COUNCIL REFERENCE: SF9786-13
CONTACT PERSON: Elizabeth Downing
YOUR REFERENCE: MP06_0060
Mod15 &
MP06_0058 MDO 15)

9 August 2016

Modification Application – combined Concept Plan and Project Approval of the Vincentia Coastal Village & District Centre
Corner of The Wool Road and Naval College Road Vincentia

Figure 1 – Subject site

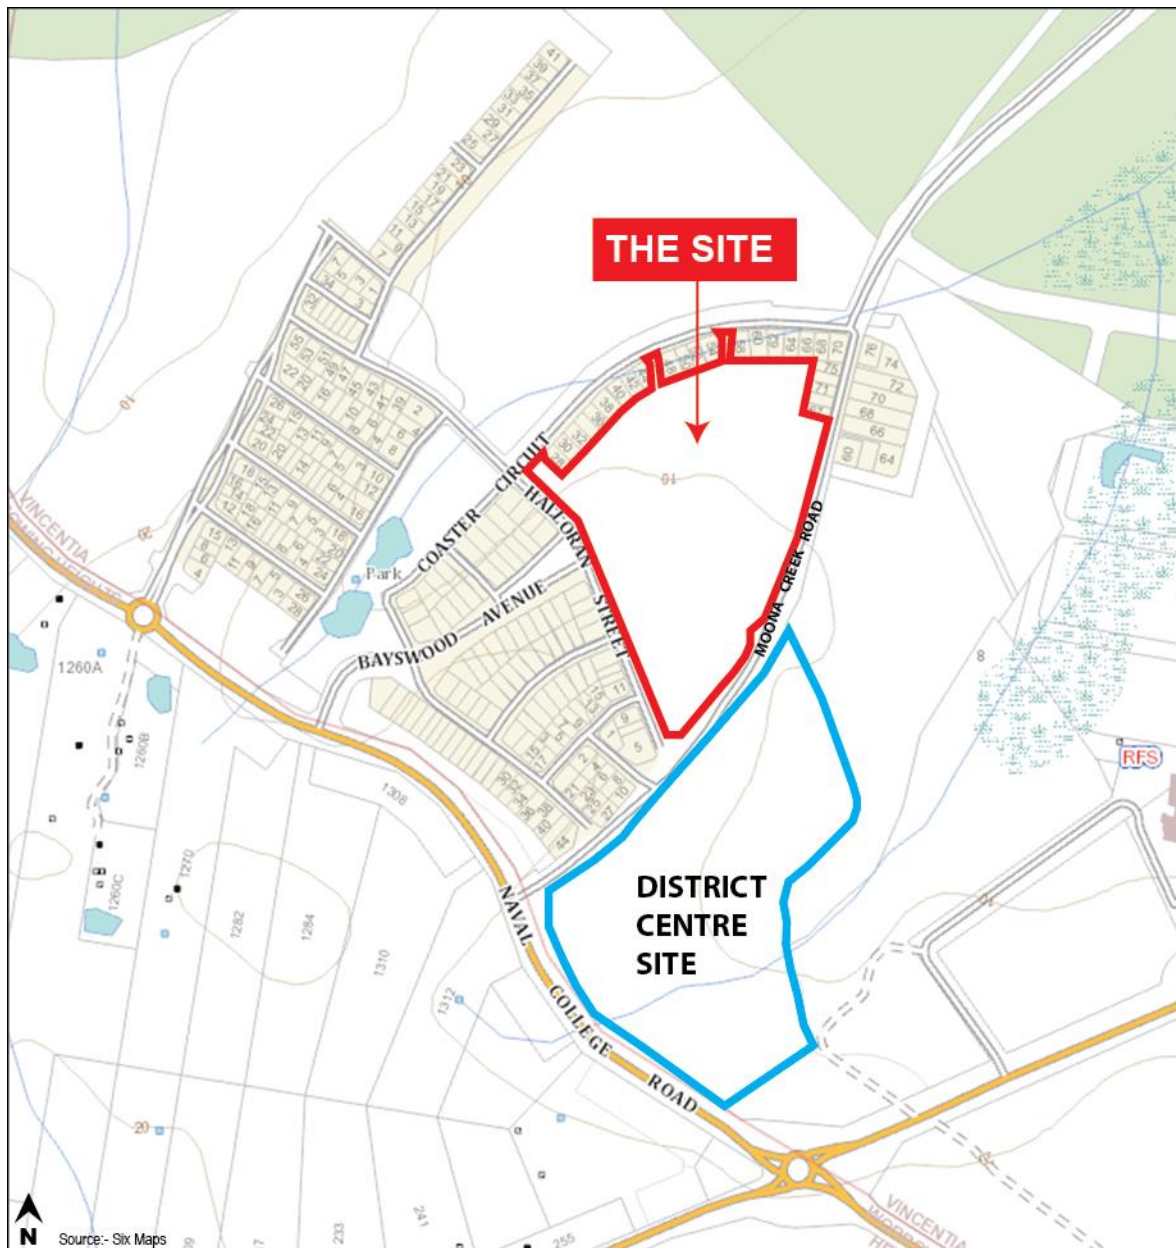
- Proposed subdivision layout plans should number the proposed roads so they can be referenced in comments.
- There is no need to continue the Bayswood Ave twin roadway and this is undesirable to Council due to the increased maintenance required. Reducing the road to a 20m road reserve with an 8m roadway around the site (see also below paragraph 5).

- The proponent's consultant proposes a second cross road in Halloran St less than 40m from an existing and more major intersection being Bayswood Ave (2 collector streets). The proposed new road is opposite Ketch Lane which could be used to access the new road and bypass traffic at the Bayswood Ave Halloran St intersection. The provision for garbage and recycling collection services along Halloran St as the new road has no turning facility is not desirable.
-

- Another road onto Halloran St is proposed close to Seabreeze Street which creates an undesirable offset intersection and is close to the Halloran St, Moona Creek Rd roundabout. Proposed lots 1618 could be improved with access off an internal cul-de-sac rather than off Halloran St or the current proposed road. Proposed lots 1601 to and including 1618 must have a restriction as to user prohibiting access of Moona Creek Road, i.e. access of the internal road only.

- The subdivision area could easily be redesigned with a through road link to the roundabout on Moona Creek Rd (creating a forth leg). Rather than the proposal to create 2 additional roads close onto Moona Creek Rd near the fire trail access all access off Moona Creek Rd should be at the roundabout. A through road could loop around the development and not just across the site via the shortest route. A redesign can be done to improve the area by creating less through activity and providing some small cul-de-sac (preferably with standard round turning heads). This would also reduce the number of internal cross roads which would be replaced with suitably spaced 'T' intersections.

- The proposed access to lots 1502 to and including 1505 is undesirable due to servicing constraints and would best be served by a knuckle type cul-de-sac and possibly an access handle lot in the northwest corner.

The applicant also appears to have provided for an indented area of parallel carparking along Halloran St from near lot 1218 to lot 1428 with the original layout only providing such close to Moona Creek Rd. Having regard to the larger lot sizes being proposed but with relatively narrow frontages, such parking provision will only permit on average 1 car per lot frontage and could not be provided across the end of the proposed road. Council's carparking code requires a minimum length of 6.5m for a parallel car space therefore, 13m is required which would leave most lots with only a 2m width of driveway (almost impossible to enter or leave with vehicles parked each side).
